KITTITAS COUNTY FIRE MARSHAL'S OFFICE

Re: NMF Enterprises (CU-14-00002)

Upon review of the above mentioned land use action, I have the following comments/requirements;

Hanson Short Plot Amendment
13-00008, Lot 1A, SEC 18, TWP
19, RGE 16

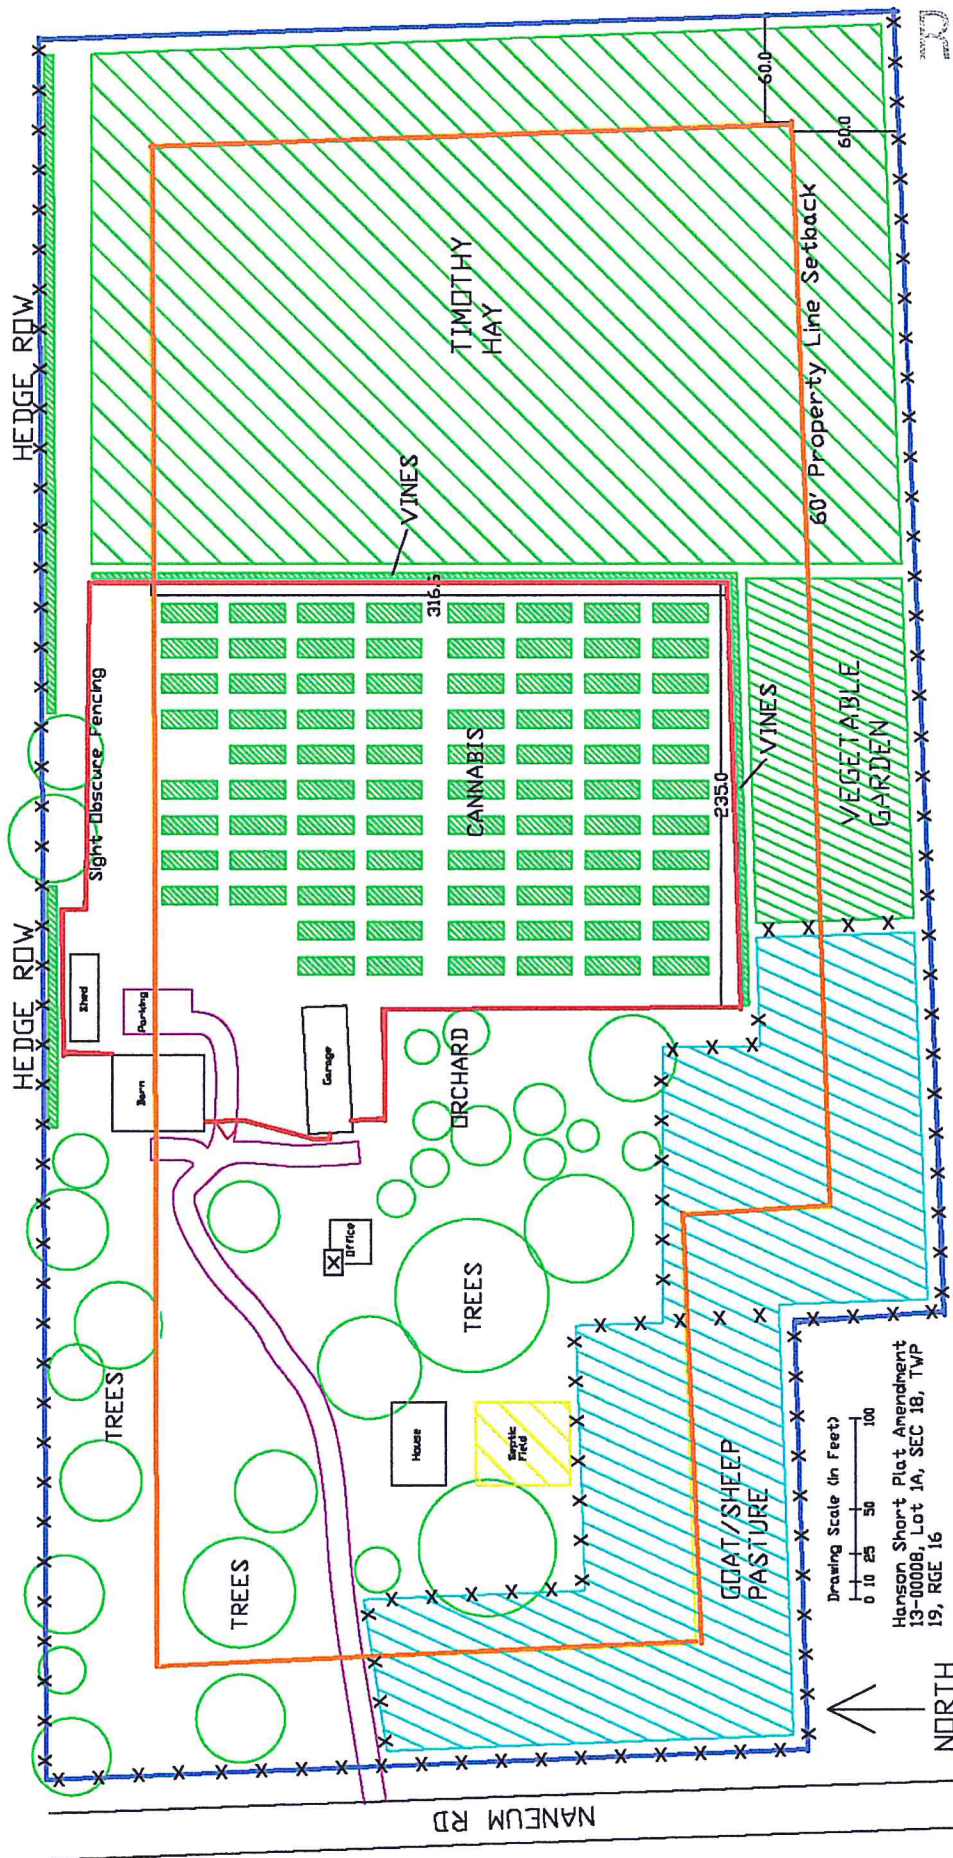
- A turn-around shall be provided for fire department access.
- It was unclear if any of the structures are to be used for storage, etc. Any use of these structures will need to be determined for appropriate fire/building code analysis, if they are going to be utilized.
